Application by Fosse Green Energy Limited for the Fosse Green Energy

The Examining Authority's third written questions and requests for information (ExQ3)

Issued on 23 April 2026

Fig 4 Route of Thorpe on the Hill Stepping Out walk superimposed on noise contour plan of distributed BESS

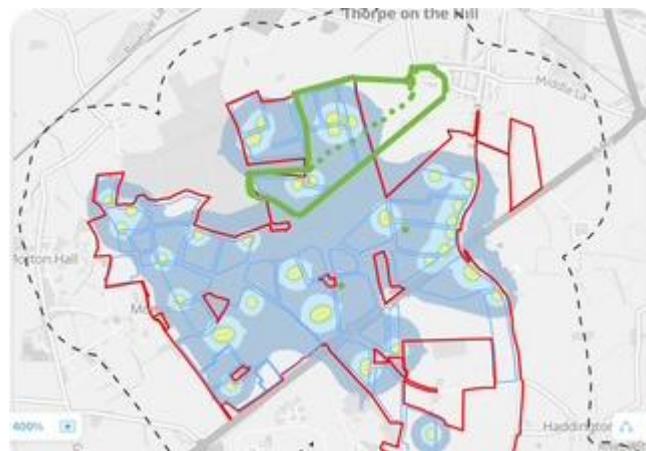
Question Number	Question to:	Question
Landscape and Visual (LV)		
LV.3.01	Applicant	<p>Visual assessment</p> <p>Part of the Bassingham and villages circular Stepping Out walk is along Clay Lane. Table 55 in Appendix 10-F (Visual Assessment) [page 171 in AS-120] relates to users of Clay Lane and Bassingham Road. The assessment presented in Table 55 finds that there would be adverse visual effects of moderate significance during construction and up to at least year 1 of operation, decreasing to minor adverse from year 15 of operation and during decommissioning, with the assessment stating that views would be <i>“experienced at speed and short lived”</i>. NKDC in its written representation [page 26 in REP1-057] observes that the assessment relates to the effects for motorists and suggests it places too low a value on the existing views for walkers, who will spend longer traversing this area and taking in the landscape. This point does not appear to have been addressed in the applicant’s response to written representations [REP2-030] or the LIR [REP2-031] when responding to the Stepping Out network matters.</p> <p>Comment on the Council’s point that too low a value has been placed on views for walker in this location and any implications for the assessment.</p>
